From: James Cross <James.Cross@arun.gov.uk>
Sent: 03 January 2020 13:58
To: Planning.Responses <Planning.Responses@arun.gov.uk>
Subject: FW: RE: FP/185/19/PL - Mermaid and Playbox, Sea Road, Felpham, PO22 7AW

Further to your previous correspondence with my colleague Richard Castro-Parker, I am writing to update you that this application has now been passed to me for determination, following Richard's end of contract with the Council. I spoke with Richard before he left regarding this application and have also discussed matters with line management. At present, there are two main issues outstanding comprising (1) Flood Risk and (2) Impacts upon Neighbouring Amenity.

BLOCK PLAN

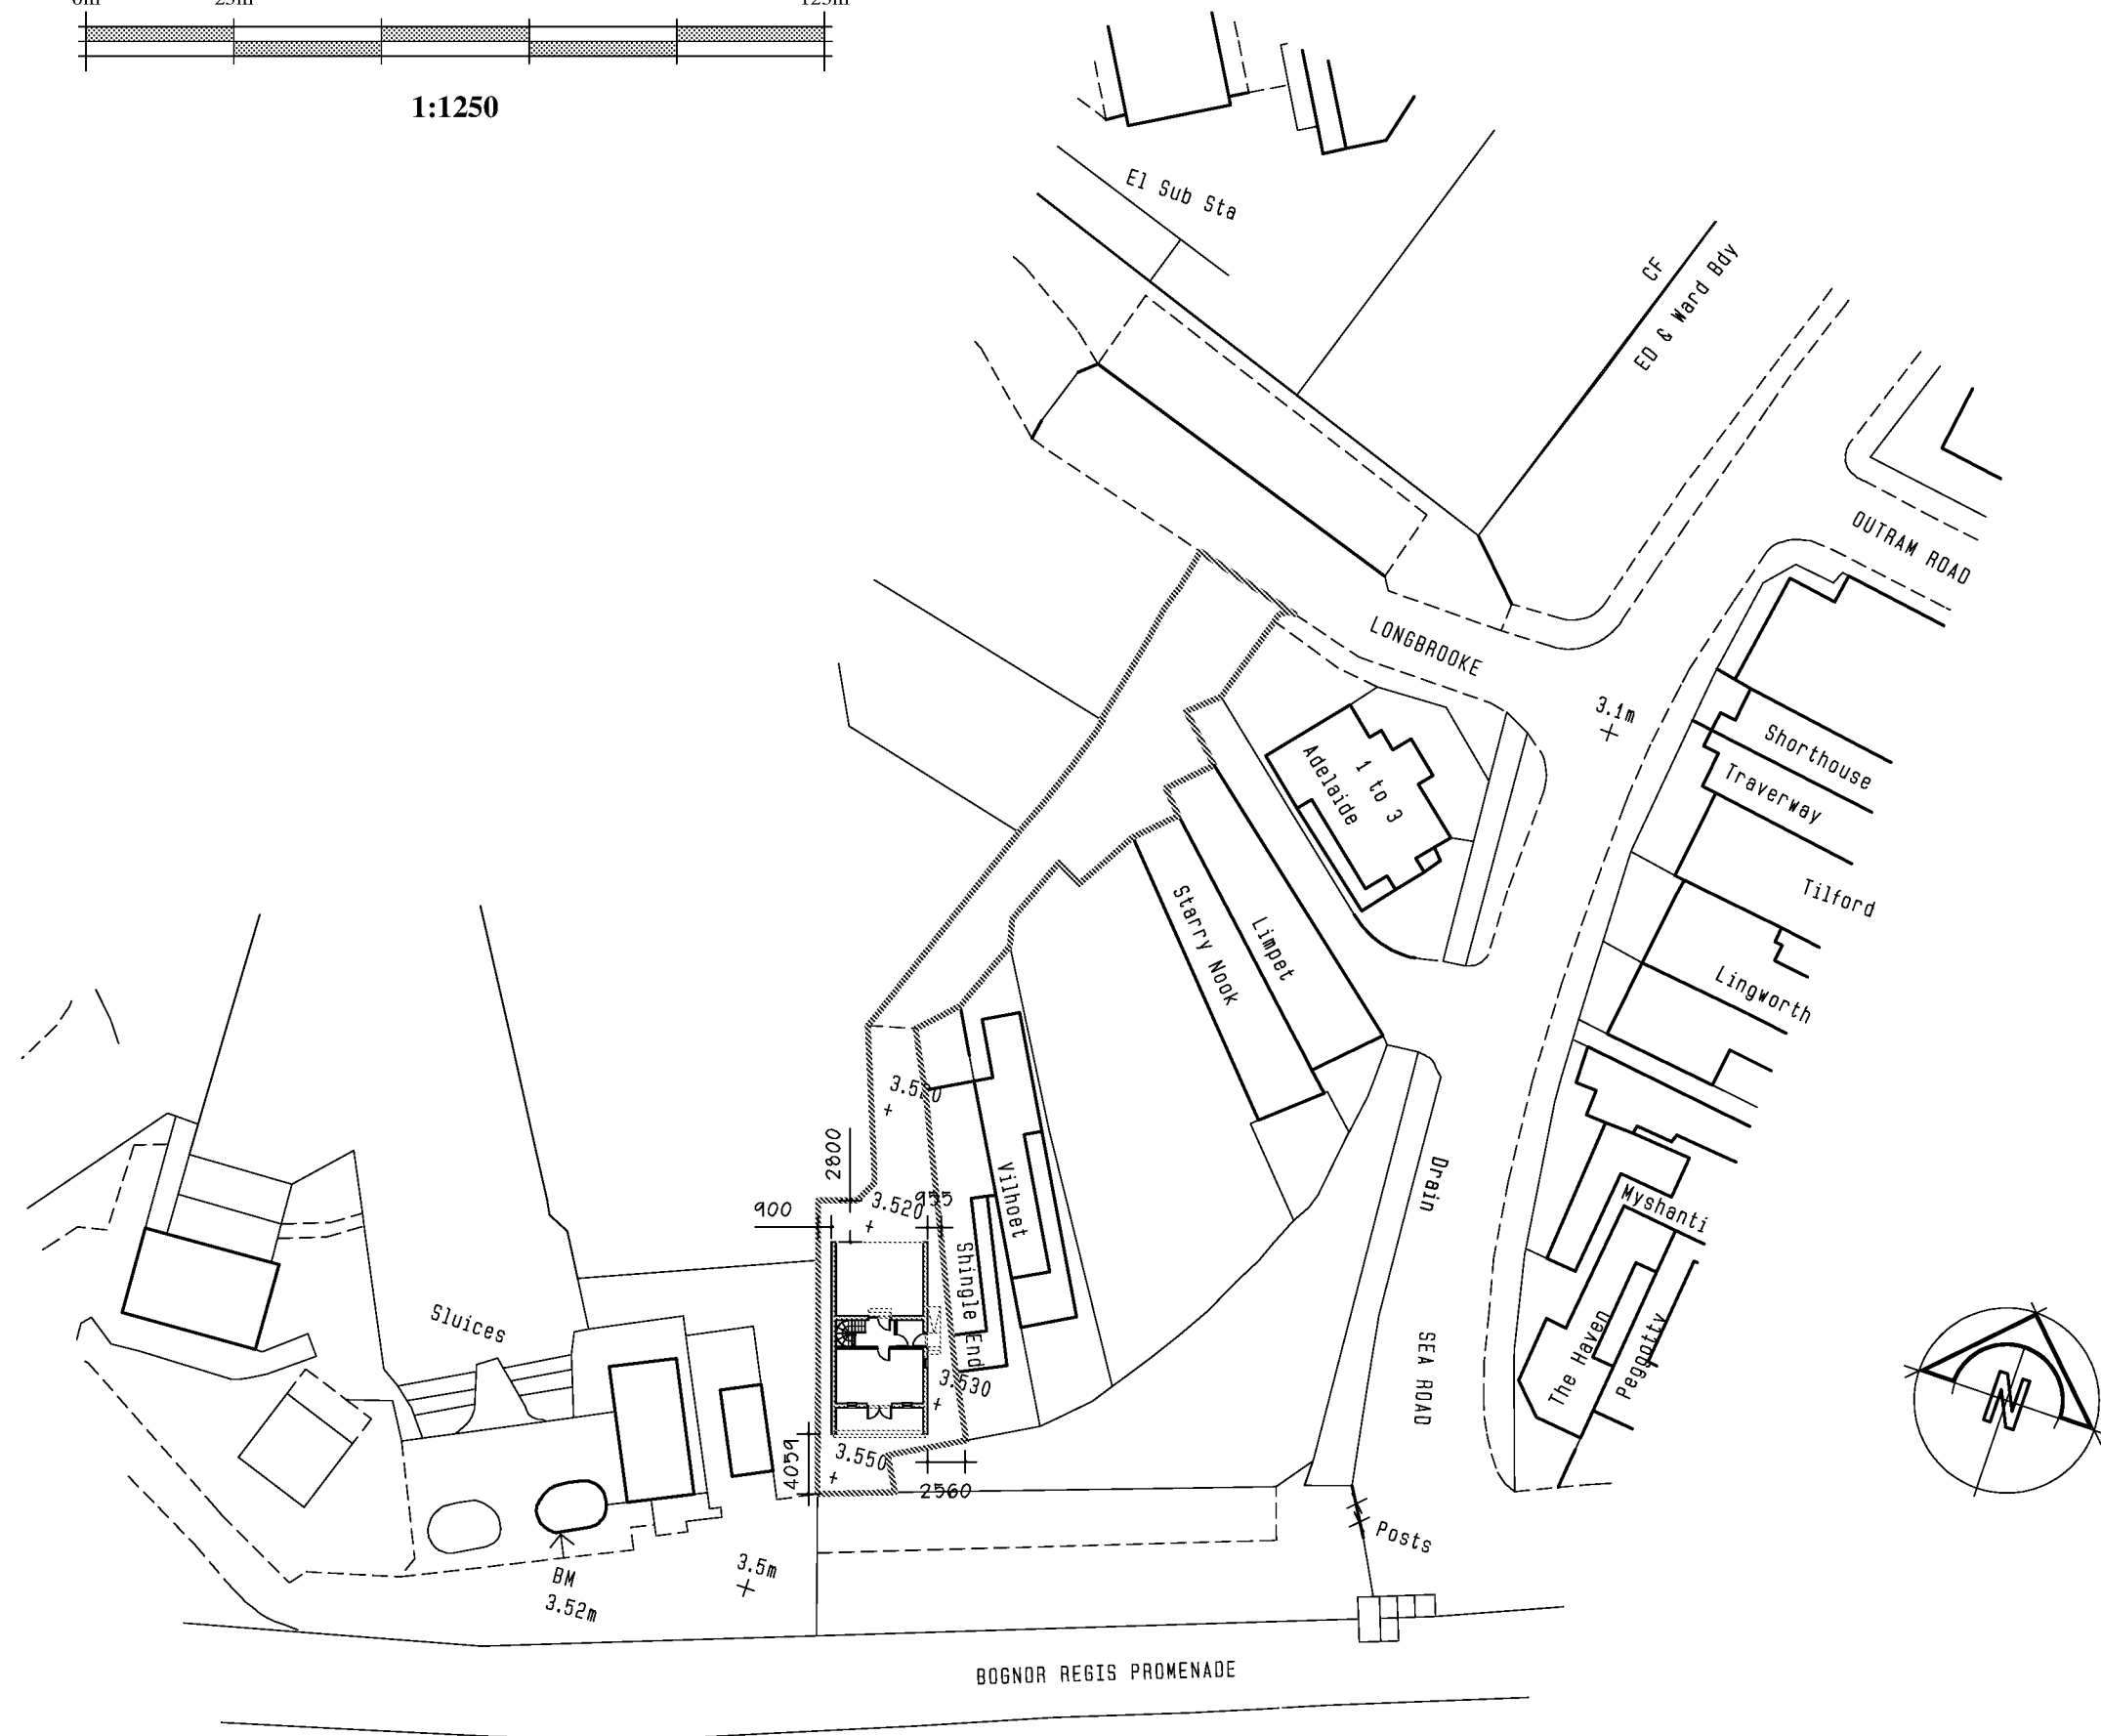
Having reviewed the proposed development, including its proximity to the western windows of the adjacent property to the east, I would consider that the development, combined with its overall height, will result in an adverse impact upon neighbouring regarding access to sunlight and daylight and also result in an over massing and overbearing. This would result in demonstrable harm to the amenities of neighbouring occupants. Whilst the submission of a BRE sunlight/daylight study may overcome concerns to access to sunlight and daylight, this would not overcome and resolve the Council's concerns regarding the over massing and overbearing impact upon neighbouring amenity.

I discussed whether a reduction in height, scale and massing of the building would overcome concerns with our management. However, it is the proximity of built development being 1.7m at best, and 0.9m at worst, being so close to the windows of the neighbouring property, that causes these issues. A reduction in height to a single storey on the same footprint would not be able to overcome these issues as the proximity would remain the same.
